# **A46 Newark Bypass**

**Scheme Number: TR010065**

## **Statement of Common Ground with Newark and Sherwood District Council 'NSDC'**

**February 2025**

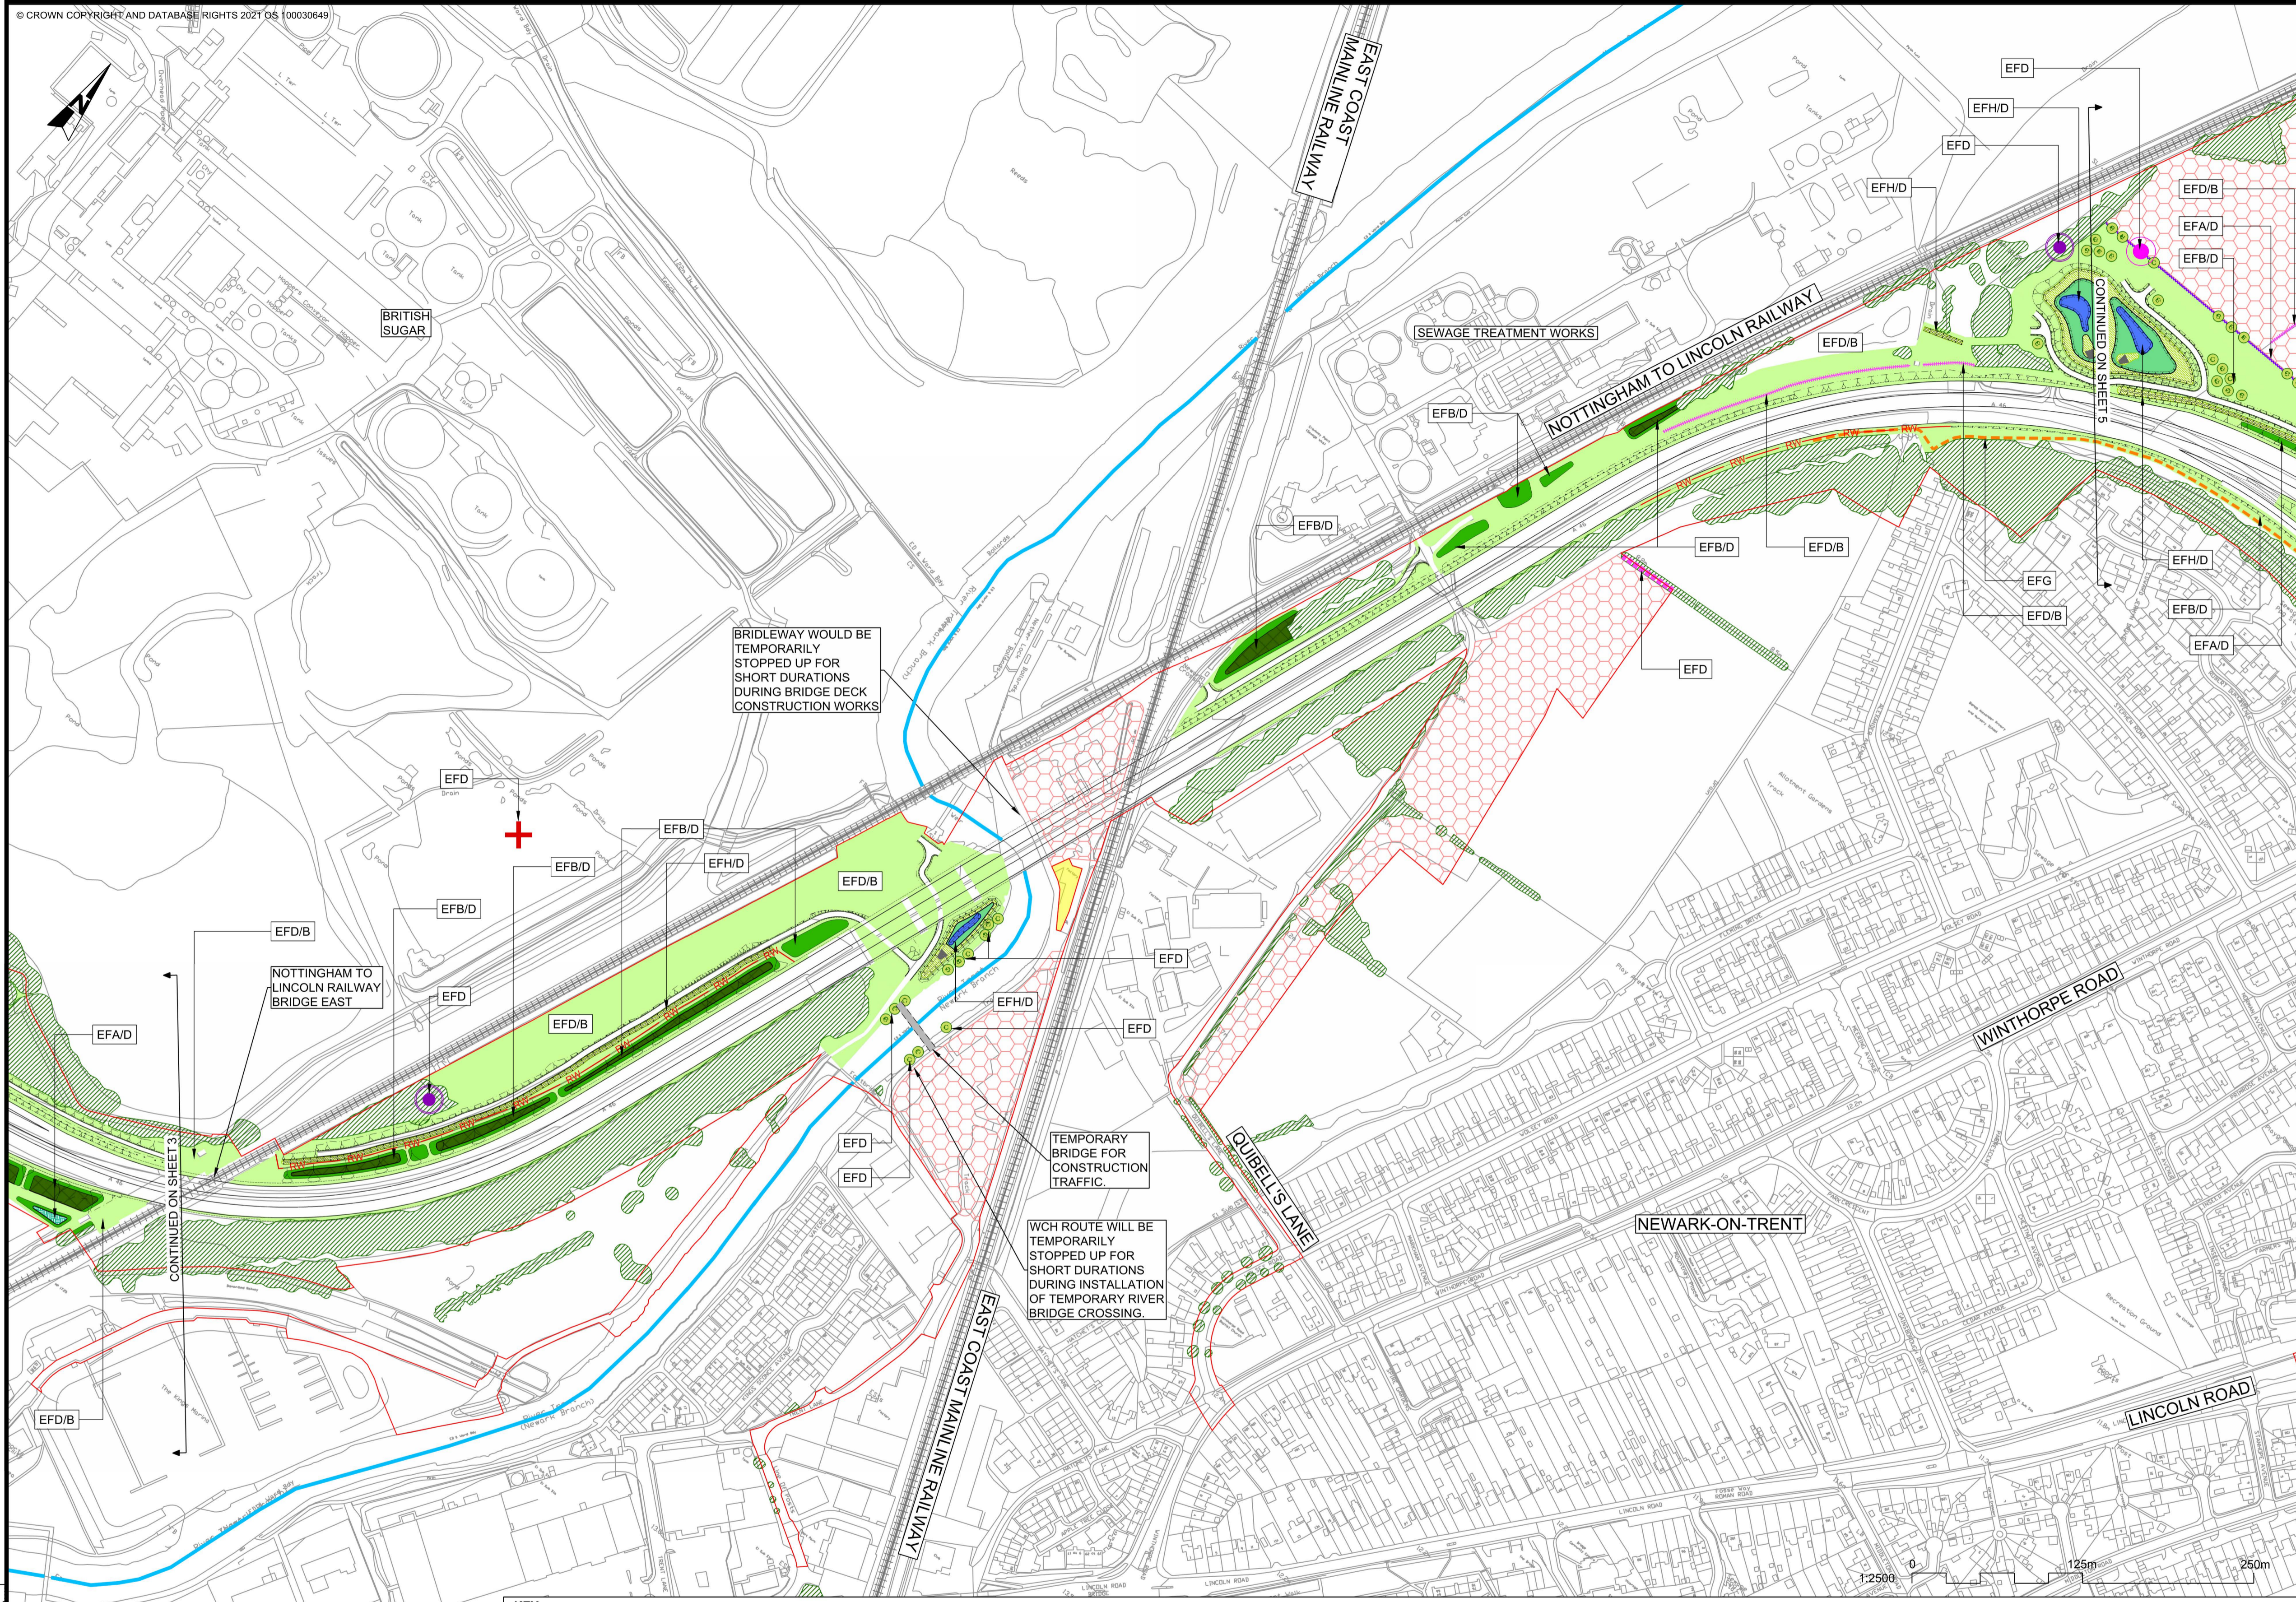
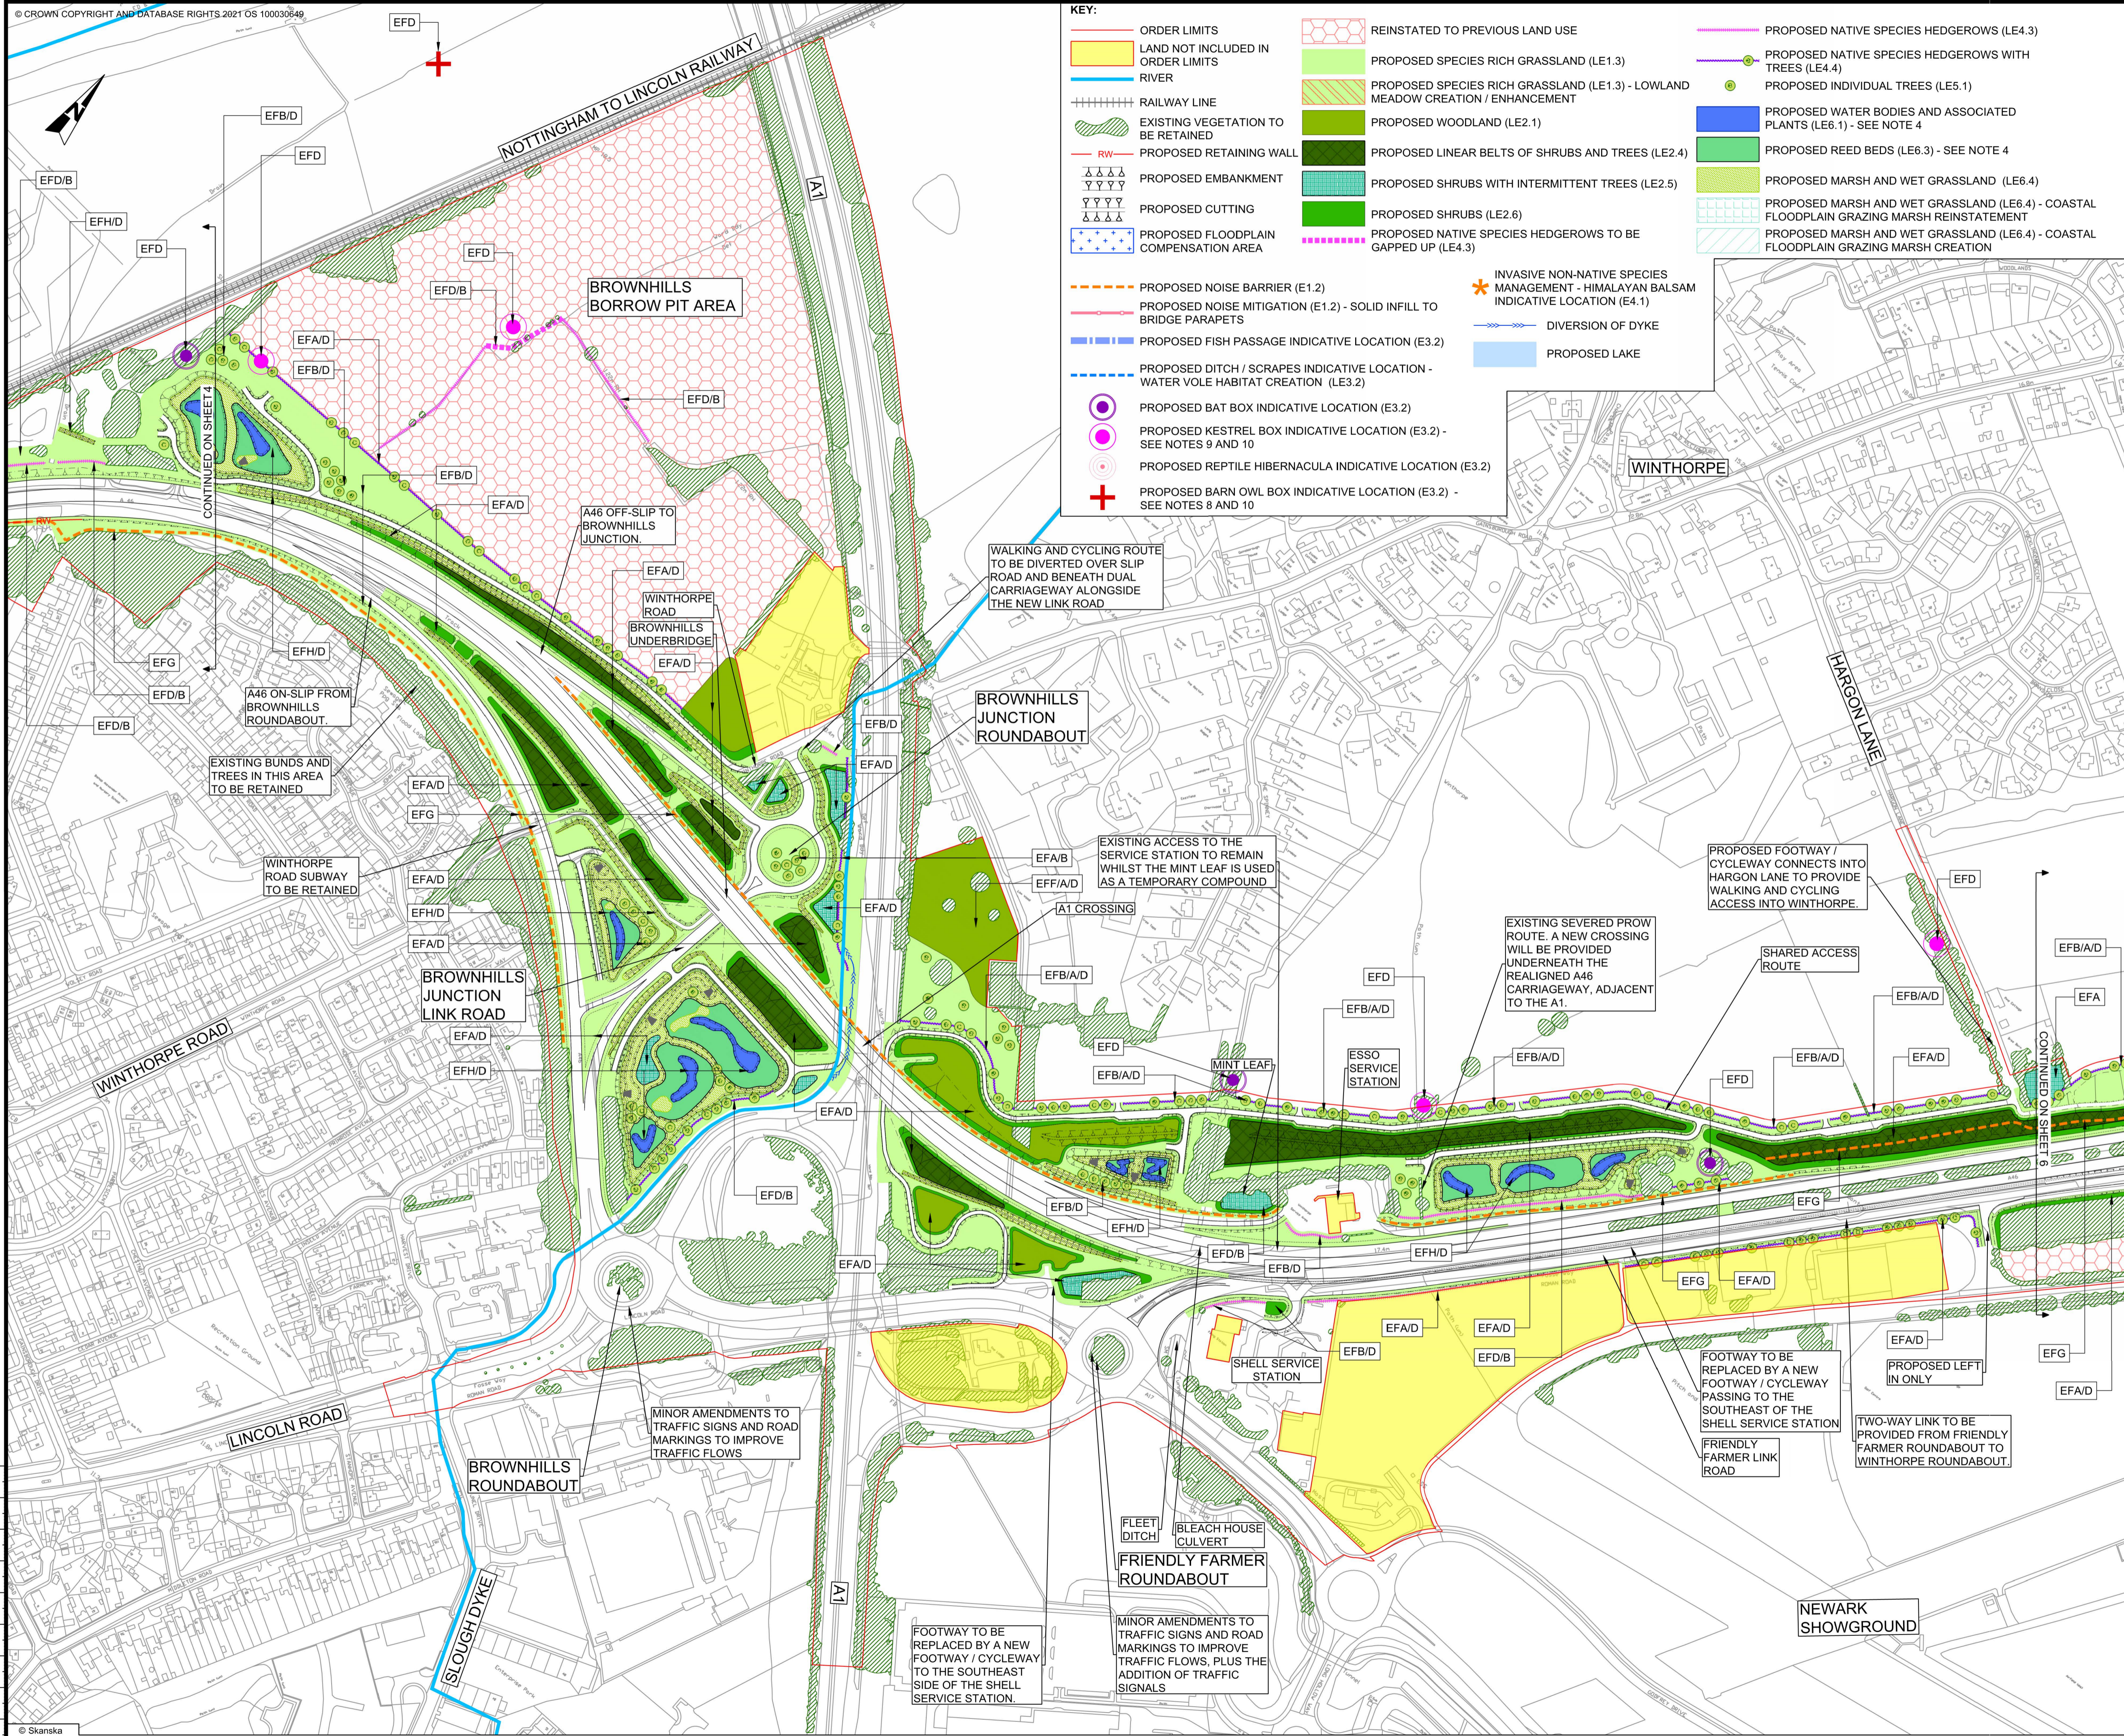
12.	Design (including justification for any flexibility being sought)	Chapter 2 The Scheme of the Environmental Statement [APP-046]  6.2 Environmental Statement - Figure 2.3 Environmental Masterplan [AS-026]	<b><u>Cattle Market flyover</u></b>  On the fly-through video the structure of the elevated over-pass at the Cattle Market junction appears as a stark and imposing concrete structure. This may be in part due to the animation which depicts it as being very bright in colour and therefore standing out vividly. The Council would want to understand proposals to ensure the visible impact of the final structure is minimised and/or mitigated as far as practicable.  03/02/2025 – Although this structure is now understood we still continue to raise concern with the impact the structure would have on the surrounding area.	Consideration has been given to the aesthetic finish of the structure during the design development to help to reduce the visual prominence of the structure and to reflect finishes on existing structures such as that of Smeaton's Arches just to the north of the new junction. Further details of these can be found within Chapter 2 The Scheme of the Environmental Statement [APP-046] and 6.2 Environmental Statement - Figure 2.3 Environmental Masterplan [AS-026].  Planting of trees and shrubs has also been considered and incorporated wherever feasible to help break up the visual mass of the structure, with planting softening the built form and aiding screening over time, particularly from properties such as those in Sandhills Park affording near distance views.  The assessment of landscape and visual effects and associated design and mitigation measures are described in 6.2 Environmental Statement - Figure 2.3 Environmental Masterplan [AS-026] and presented in 6.2 Environmental Statement - Figure 2.3 Environmental Masterplan [APP-026].  Part of the Detailed Design process will be to define the finish of the retaining walls forming the Cattle Market Flyover. This will be a masonry type façade and not a bare concrete finish.	Under Discussion	16/10/2024
